Project Name: **PERFECTO, MARIANO & JESUS ARMIJO ADDITION**

**CITY OF ALBUQUERQUE  
PLANNING DEPARTMENT  
March 22, 2007  
DRB Comments**

**PROJECT # 1004183      APPLICATION # 07-00350**

**RE: Block 7, Perfecto, Mariano & Jesus Armijo Addition/plat**

PLAT OF
LOTS B-1-A, B-2-A & B-2-B, BLOCK 7
PERFECTO, MARIANO & JESUS ARMIJO ADDITION
PROJECTED SECTION 17, T. 10 N., R. 3 E., N.M.P.M.
TOWN OF ALBUQUERQUE GRANT
CITY OF ALBUQUERQUE
BERNALILLO COUNTY, NEW MEXICO
MARCH 2007

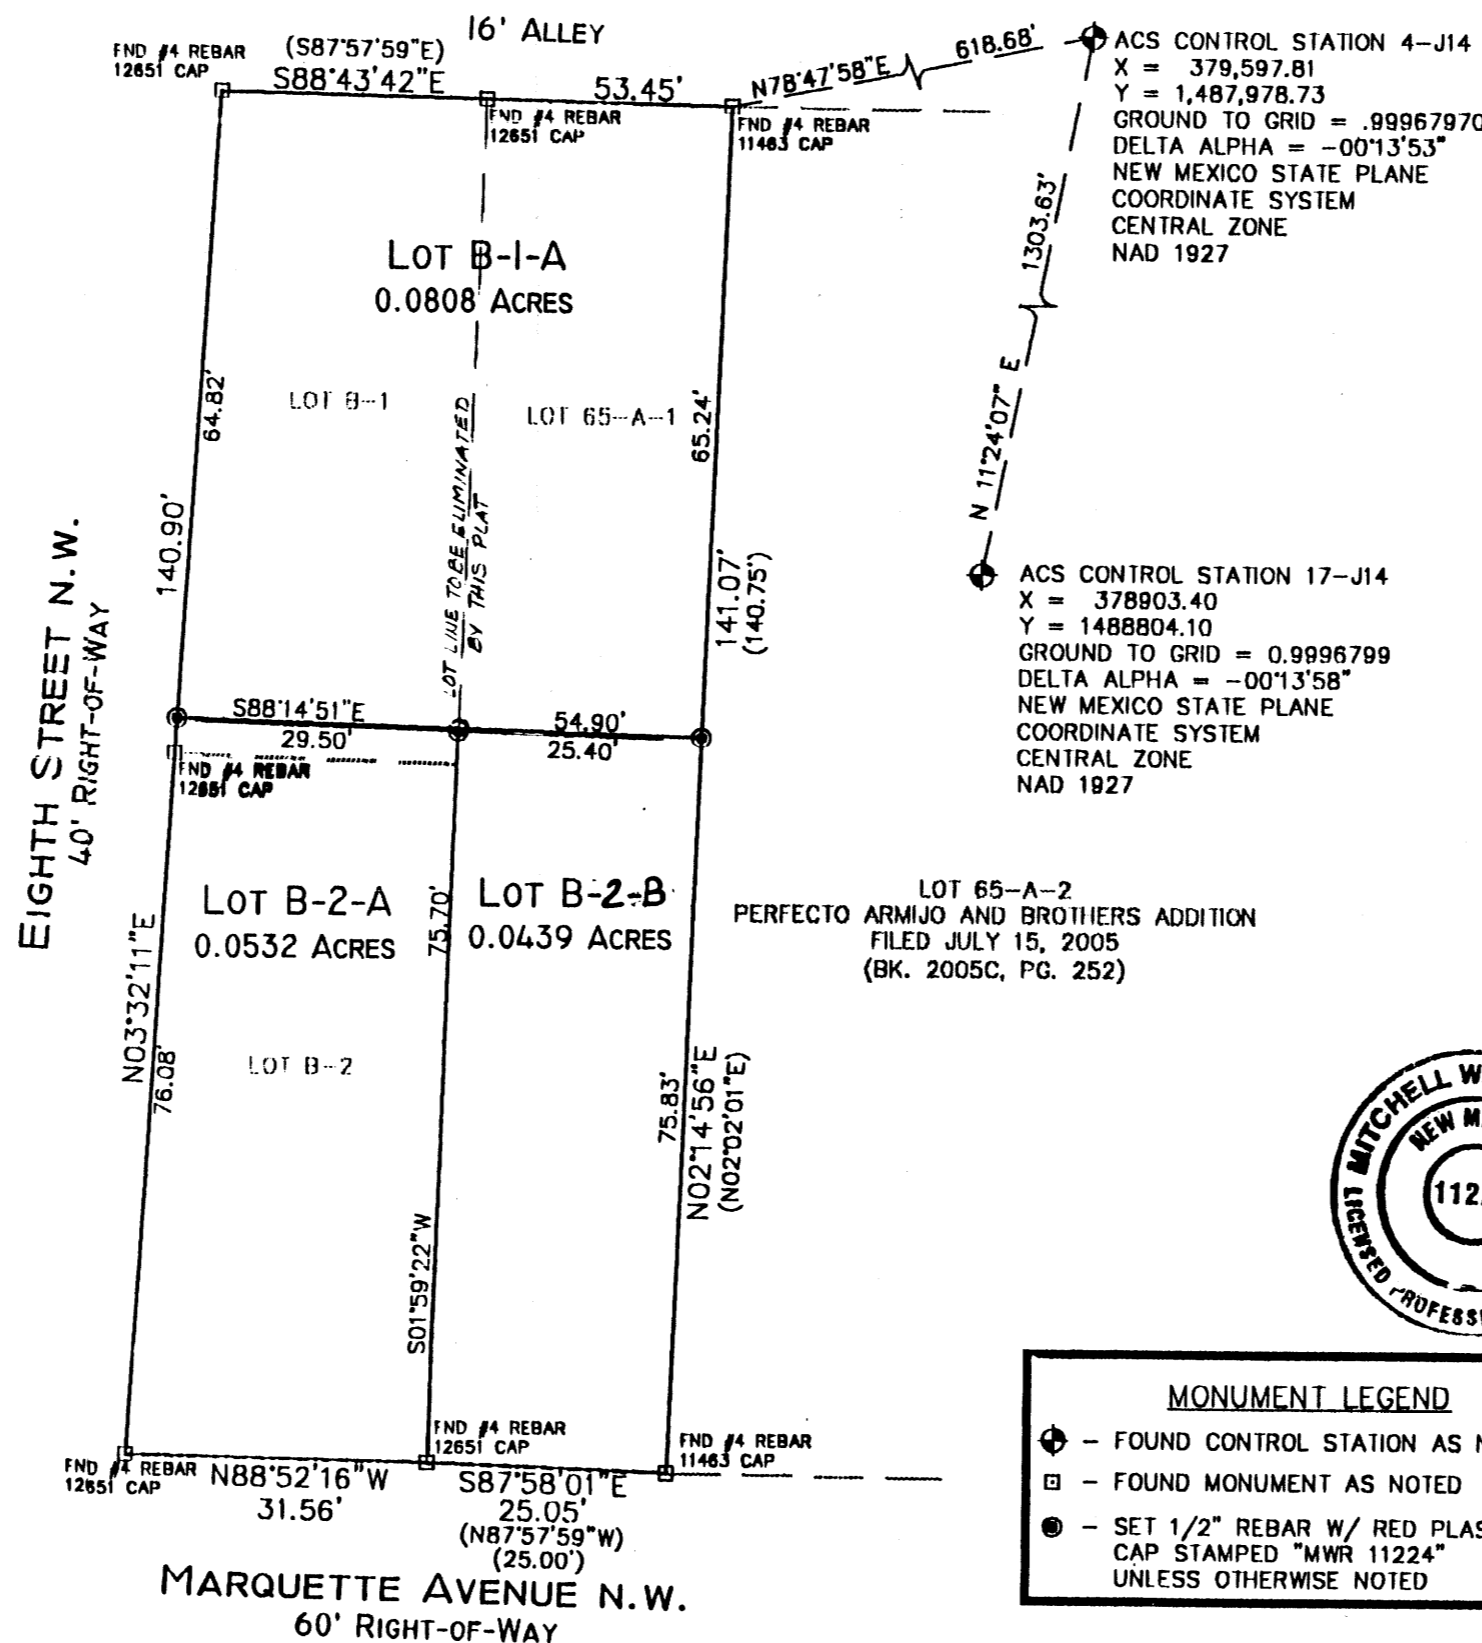
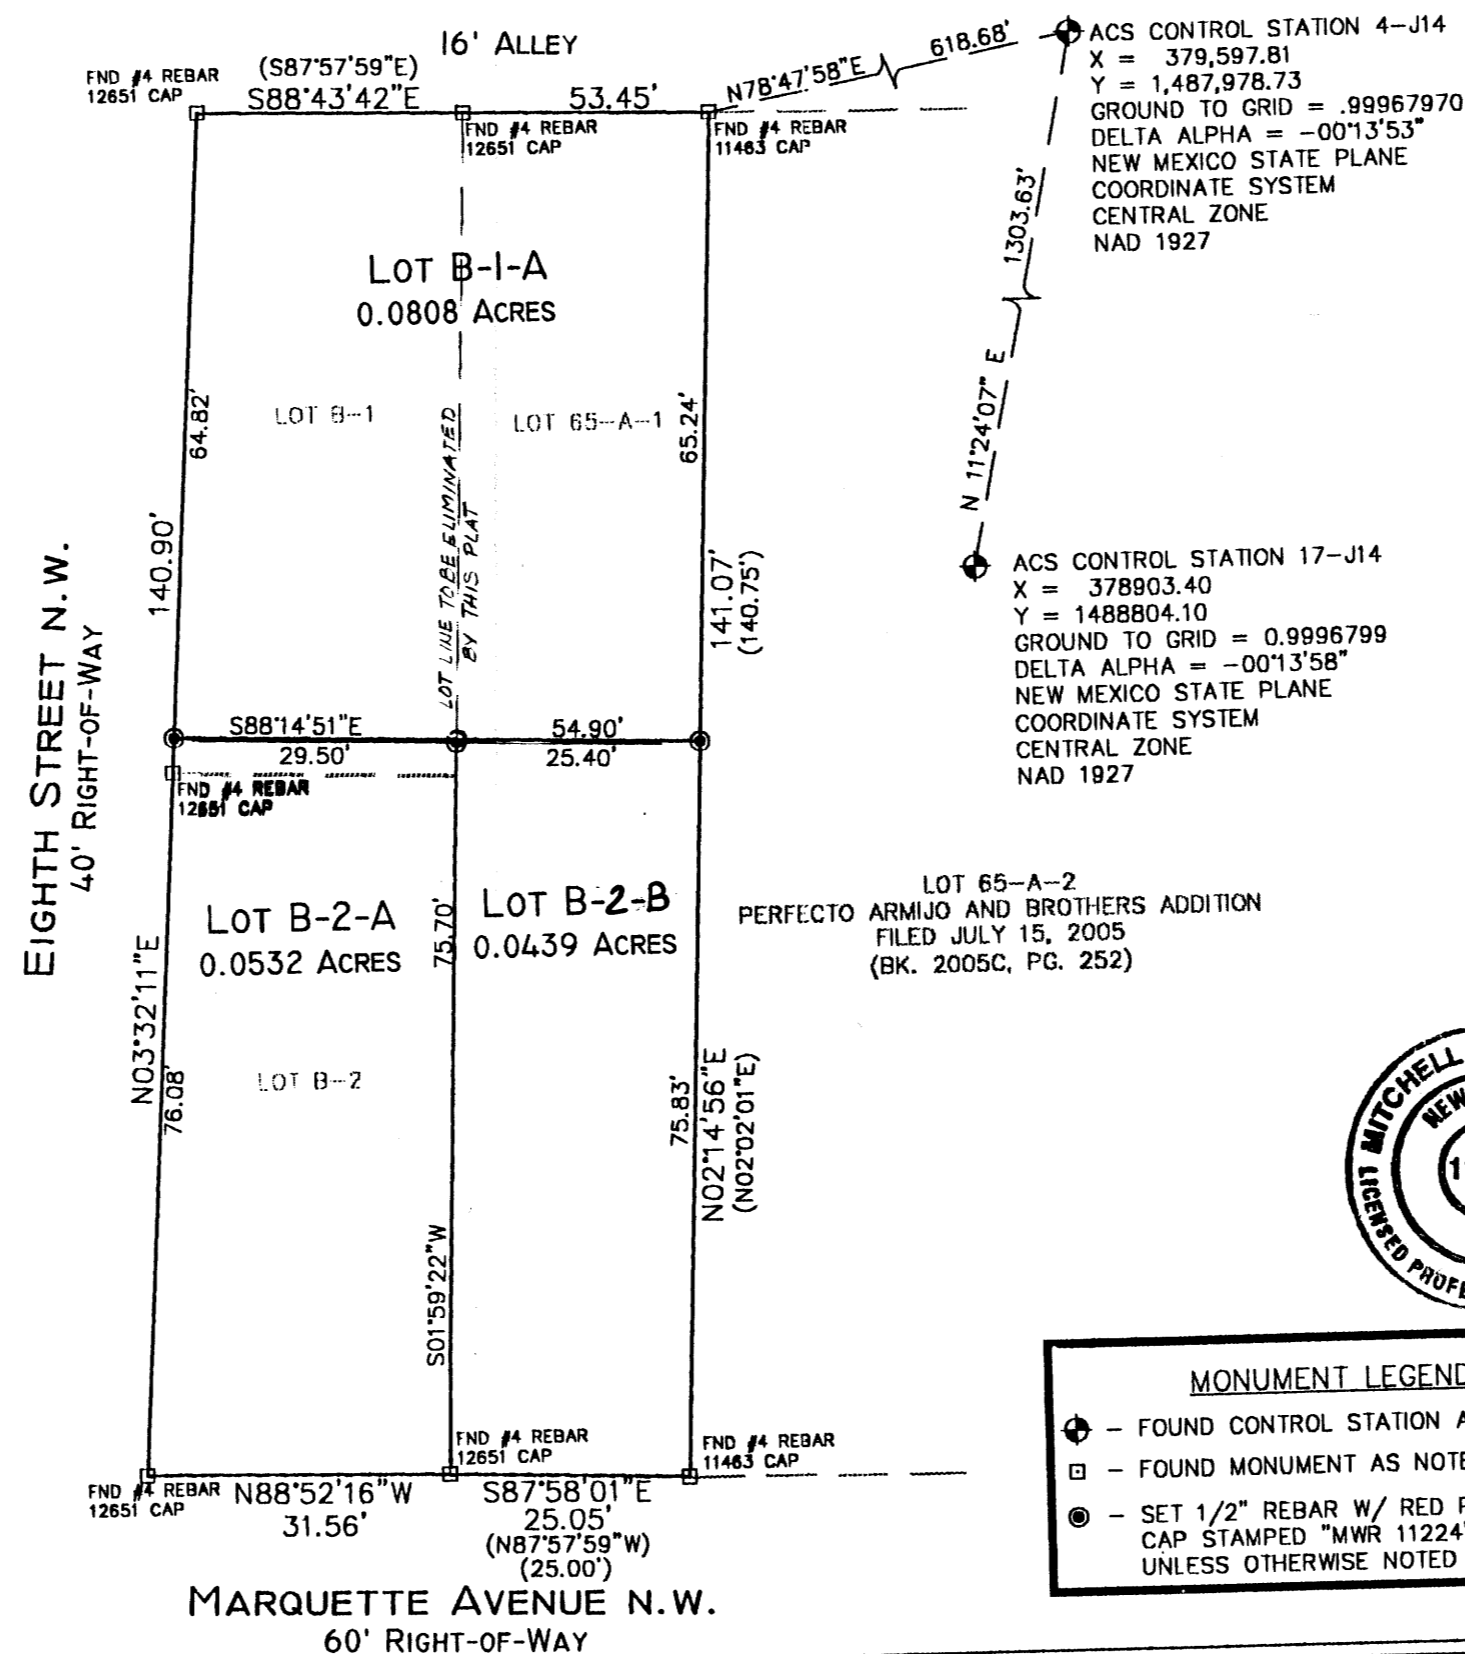
If the front of the existing residence faces Marquette, the proposed east property line for that lot is okay because RT zoning, to which SU2-HDA refers, does not require a side yard setback in this case.

However, the required rear yard setback is 15 feet. Is the proposed lot line at least 15 feet from the existing residence?

If the front of the house faces Eighth Street, then the east side becomes the rear yard & requires a 15 foot setback.

In either case, the front yard setback requirement is not met, but it is an existing condition. So this situation is allowed.

Why are the dry utilities not signing this plat?

Please correct the zoning on the plat. AGIS dxf approved?
